**From:** Barnett, Ralph <[REDACTED]>  
**Sent:** 23 July 2021 17:10  
**To:** Margoum, Naoual <[REDACTED]>  
**Subject:** RE: PROPOSED DEREGISTRATION OF LAND ON WALTON COMMON AND TILBURY FORT COMMON (CL228) COM/3273818 [BURGES-WORK.FID9788227]

Thurrock Flexible Generation Plant Access, Rights of Way and Traffic Regulation Plans Sheet 2 of 5

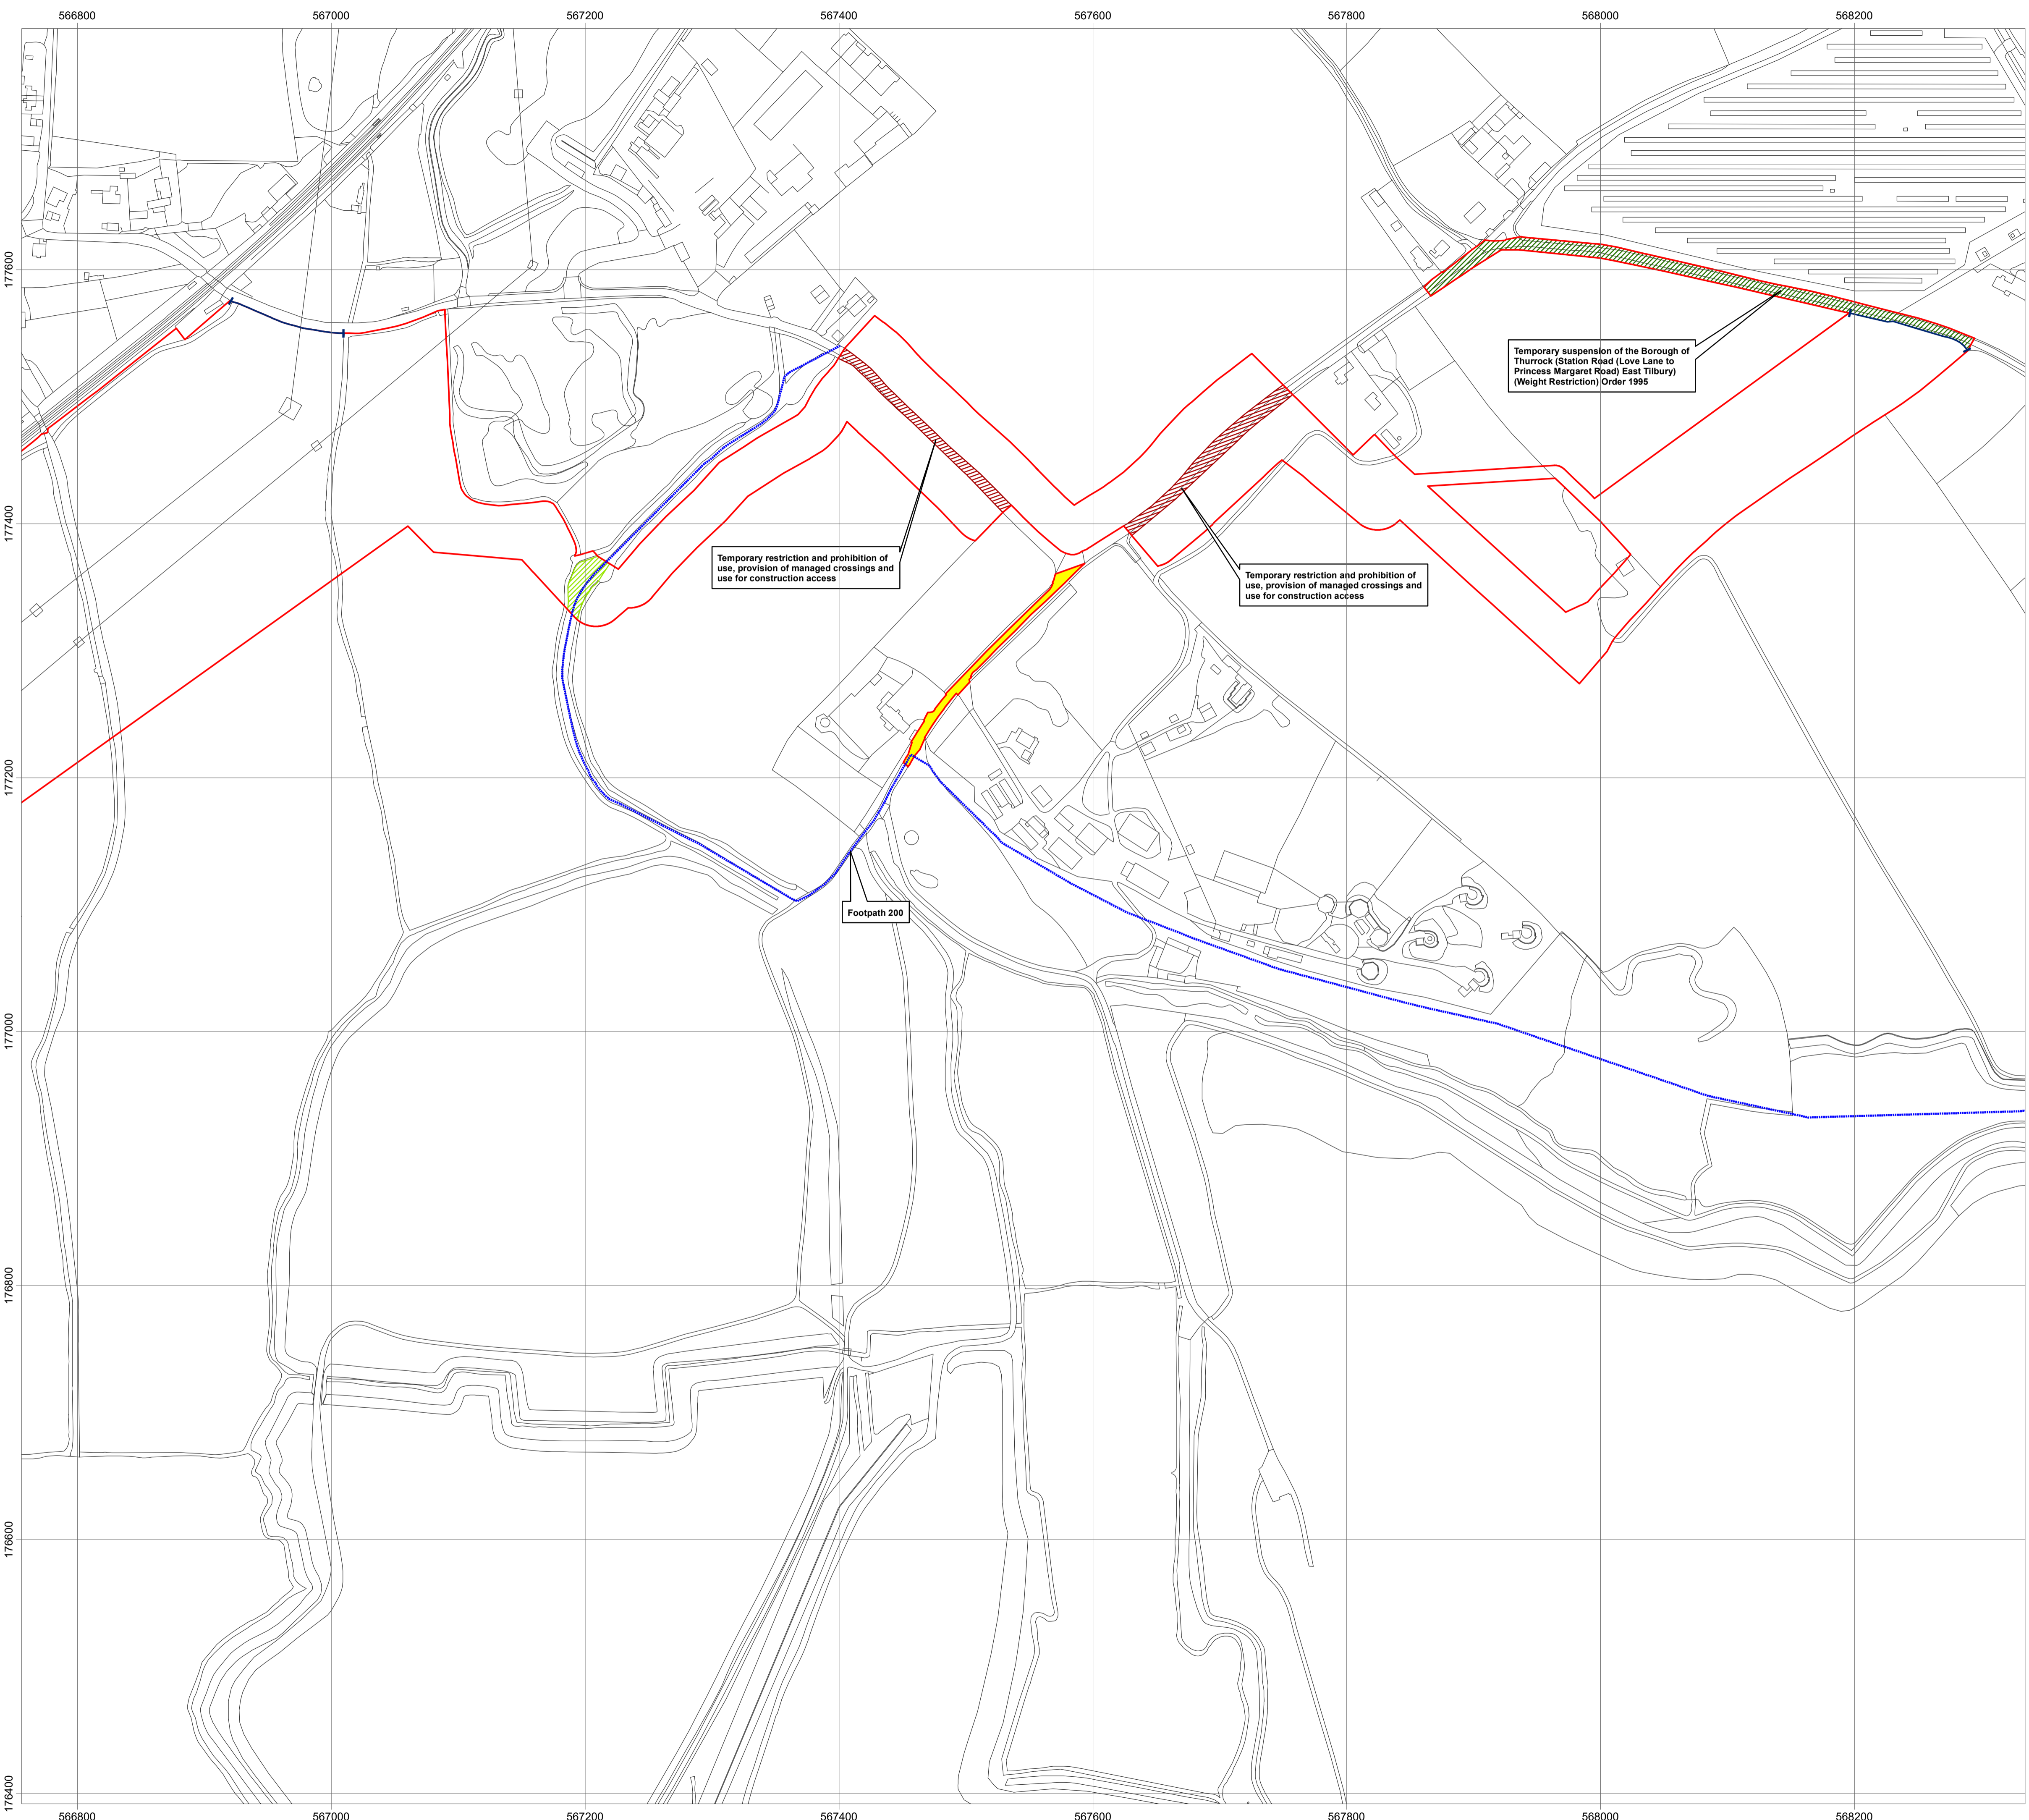
With regard to the above thank you for forwarding the applicants statement in response to the comments received by ourselves and other consultees. I can confirm that we wish to maintain our position with regard to the access to the replacement land and what we believe is the need to provide secure legal access onto the common from Tilbury, either by extending the area of common being made available in this location or via the creation of a Public Right of Way. The use of the word 'secured' to describe the permissive route as part of the DCO application is potentially misleading as the current proposal provides no security of access. We do however acknowledge the concerns of the landowners with regard to potential illegal and anti social use of the common although we feel control over the use of the land could be maintained by providing suitable structures such as bollards at this access point which would allow for access on foot and potentially on horseback but prevent vehicular access for fly tipping or other illegal use. The need for a bridge to cross the watercourse at this location is also likely to inhibit any vehicular use which could be a precursor to further anti social behaviour. The applicant refers to the reduced distances of travel such an access route in this location will provide (103 metres compared to 1802 metres) although having visited the site we believe that should the permissive access proposed be revoked at any time, the alternative route via the road to access the common from the eastern end is neither a practical or reasonable alternative. This is due to the lack of vegetation control in the road verges (which would result in people having to walk on a narrow and potentially busy road) and the lack of any clear or convenient access from the roadside into Parsonage Common. In effect, should the permissive route be revoked, the exchange land would to all practical intents and purposes as a resource for walkers and other recreational users become inaccessible. Something that would negate any benefit that could be obtained from the additional 1.5 ha of common land that will be made available.

With regard to the proposals for grassland replacement on the exchange land and future management we are grateful for the additional information that been supplied although we would continue to advocate for a more holistic plan which includes measures that also provides for the sites ongoing management for access and recreation.
